Our ref: OR-0001976
Your ref: EN010153
Date: 15 April 2026

ENVIRONMENT AGENCY DEADLINE 6 RESPONSE.

FRODSHAM SOLAR PROJECT, FRODSHAM MARSHES

Indicative Watercourse
Crossing Points

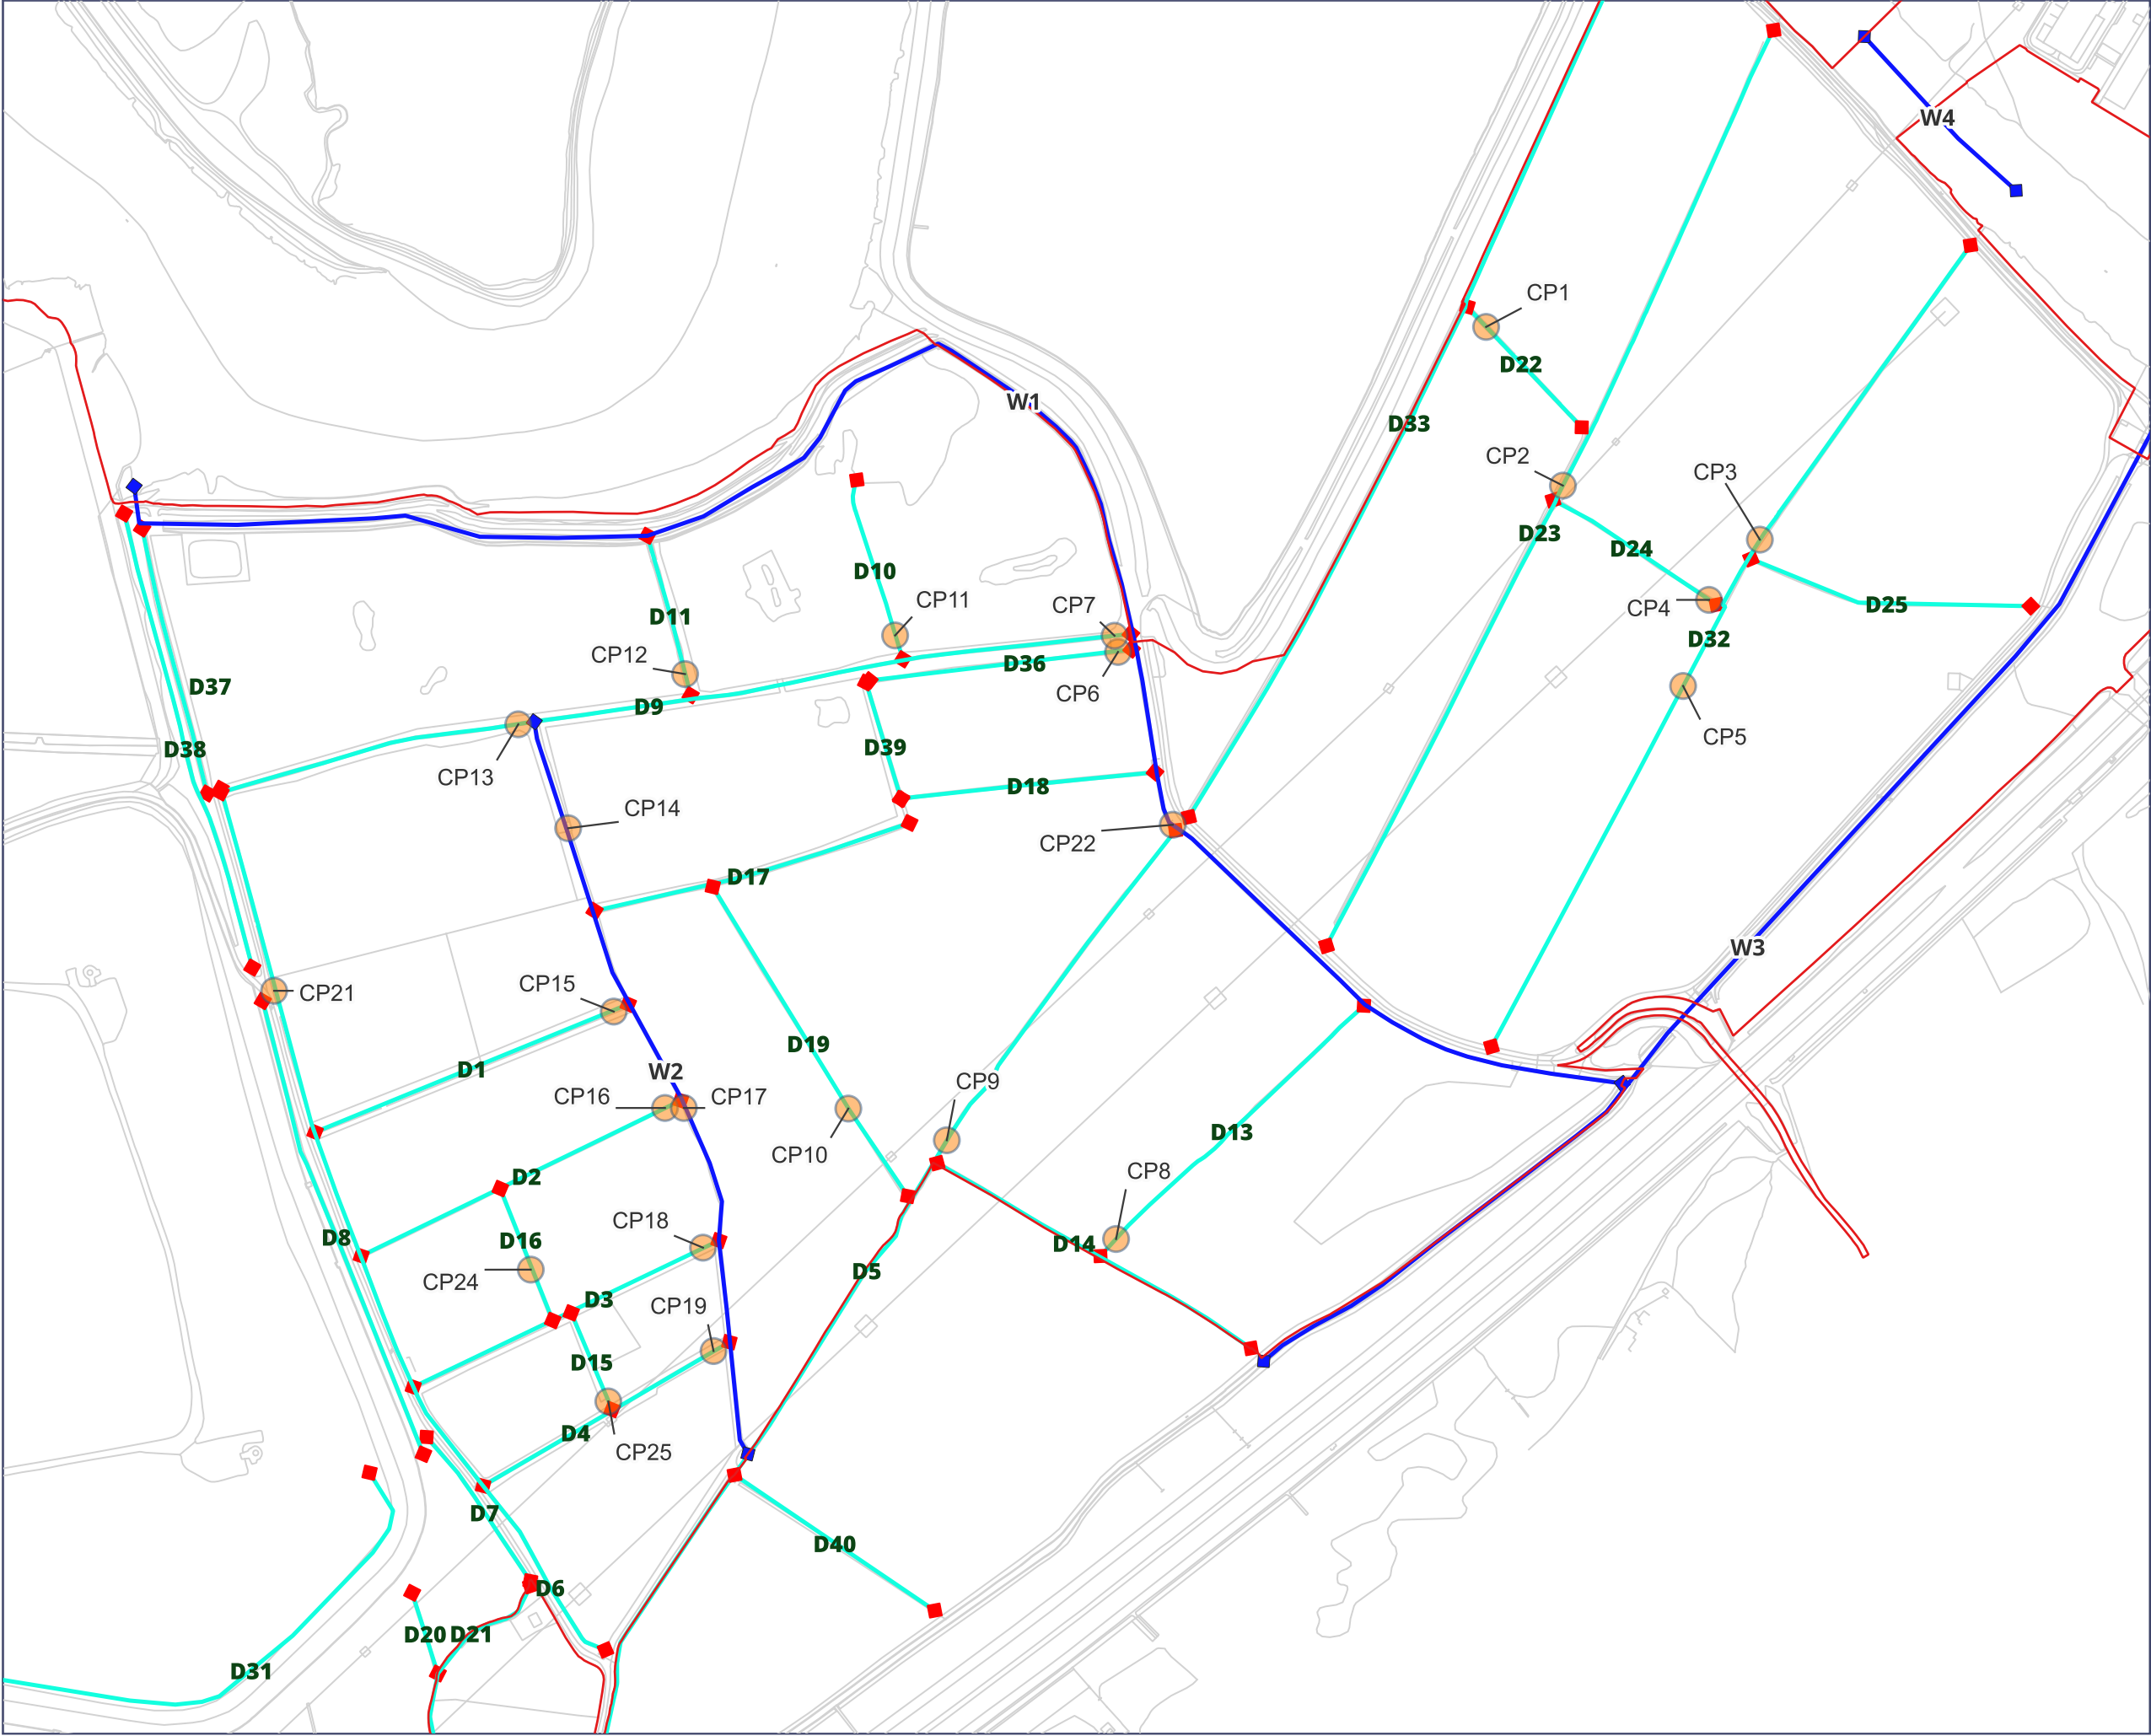
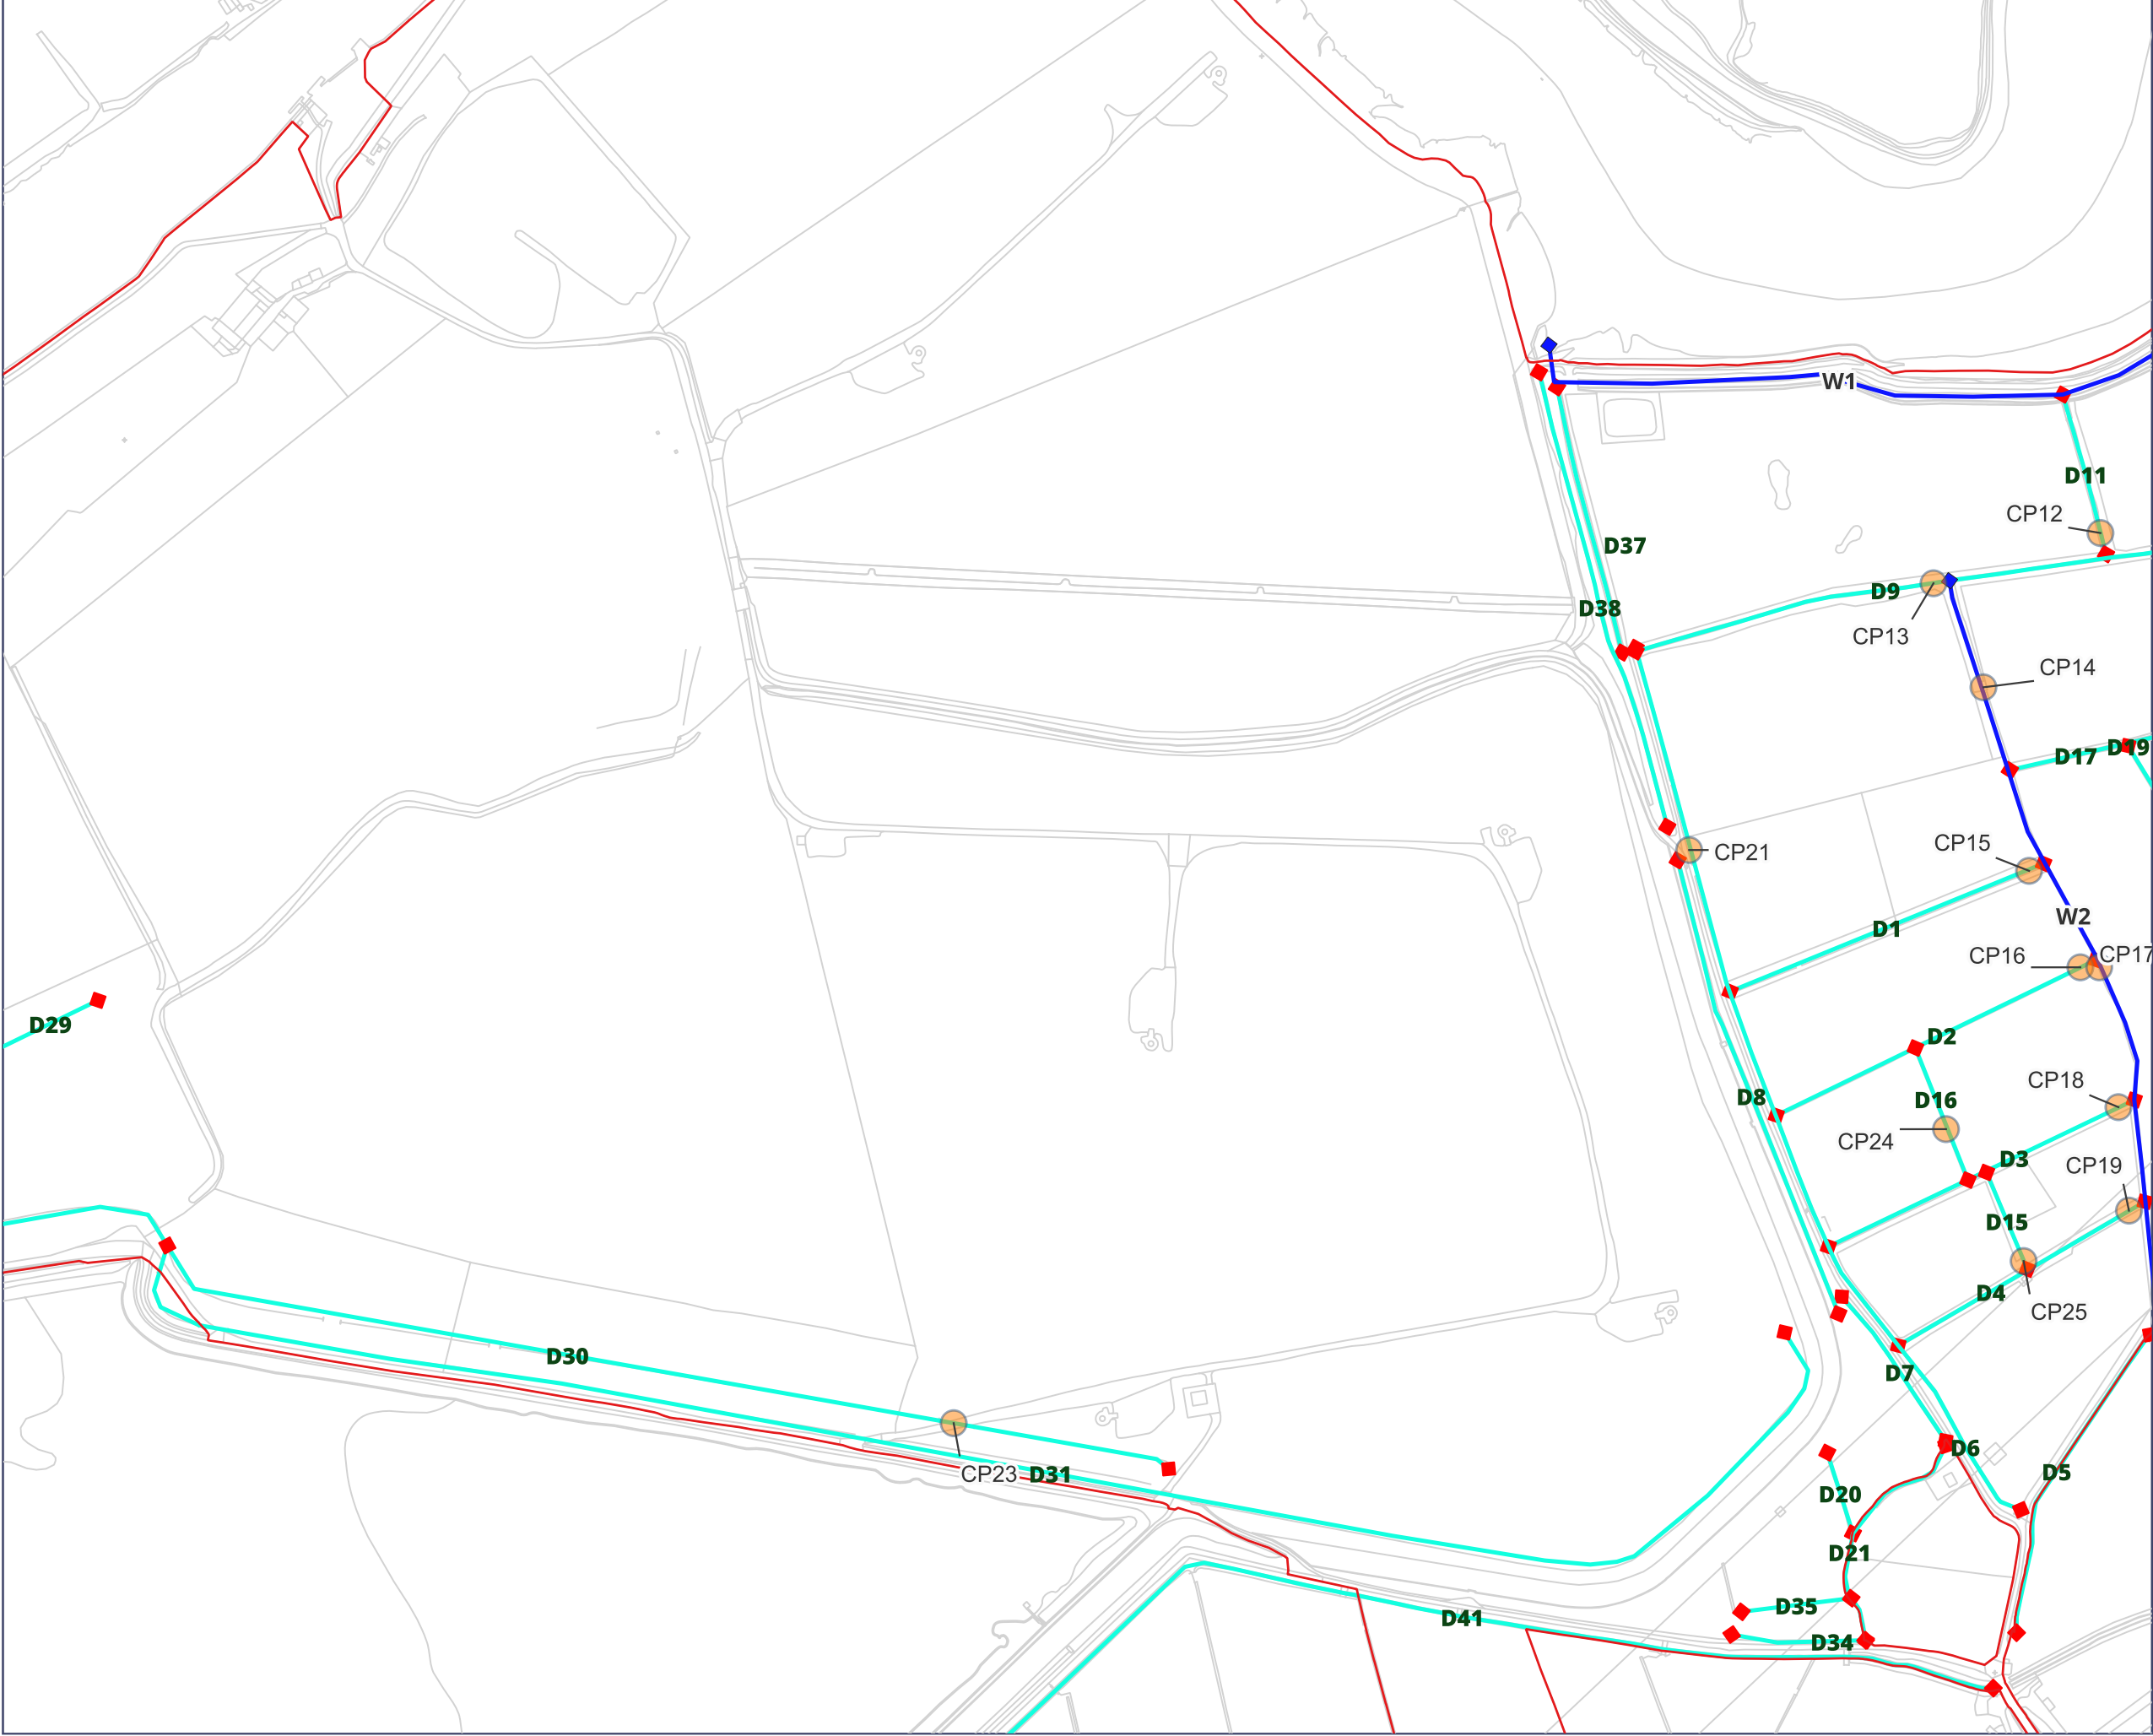
Our issue concerned the crossing design CP22, as it did not provide appropriate 300mm freeboard above the design flood event (1% AEP plus 67% CC - higher central allowance). We are content with the crossing designs for CP14 and CP17.

Outside of the examination, the Applicant has engaged with us to resolve this outstanding issue for CP22. The Applicant has proposed an alternative CP22 crossing design with supporting information for our approval (ref.14740-WCD-XX-XX-SK-S-006 P02, dated 23 March 2026). This design includes a raised crossing providing a 300mm freeboard from the base of the bridge steels to the in-channel flood level (flood level of 4.76m Above Ordnance Datum). They have also demonstrated that the raised road levels will not increase flood risk elsewhere.

The alternative bridge design and supporting information provided is sufficient to resolve our concerns regarding issue EA007. We are therefore content to agree this issue as resolved, subject to the submission of the alternative CP22 bridge design and supporting documentation at Deadline 6.
